MEMORANDUM

TO: Jean Fraser, Planner
FROM: David Senus, P.E. & Ashley Auger, E.I.T.
DATE: January 16, 2013
RE: Final Level III Site Plan Application – Old Barn Estates, Ledgewood Drive off Ocean Ave

EROSION AND SEDIMENTATION NOTES AND DETAILS

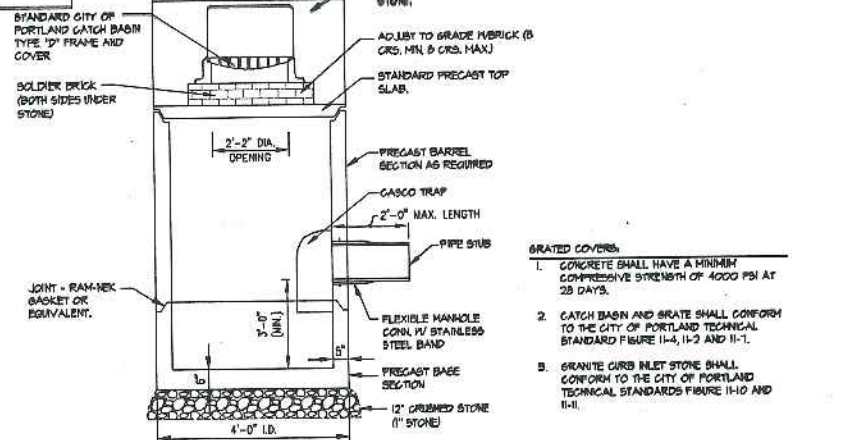
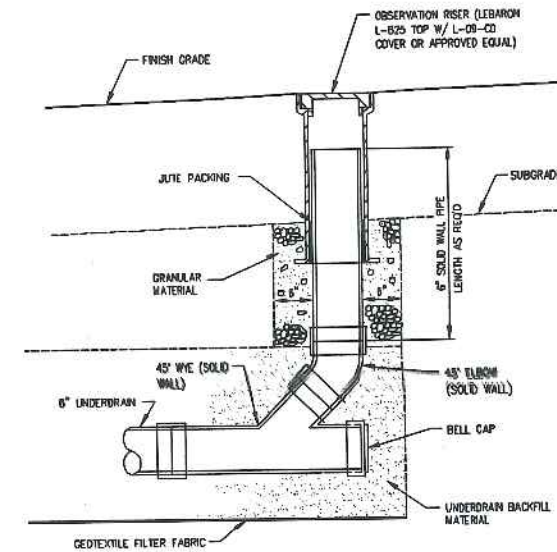
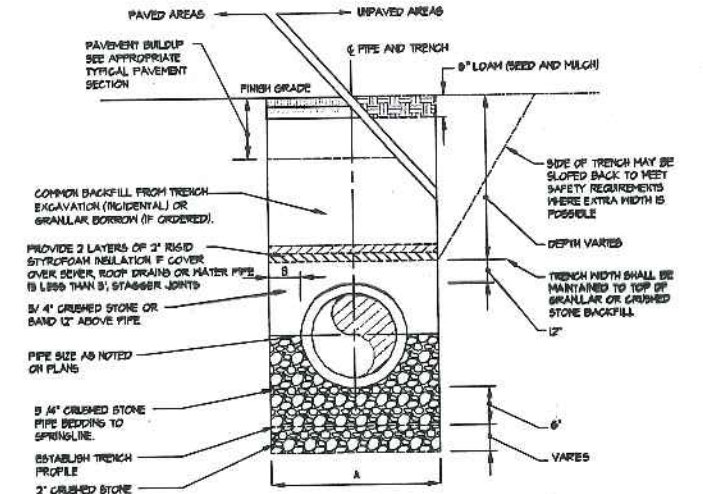
- (3) The Grassed Underdrained Soil Filter detail on C-302 should include a geotextile fabric between natural soils and constructed media.
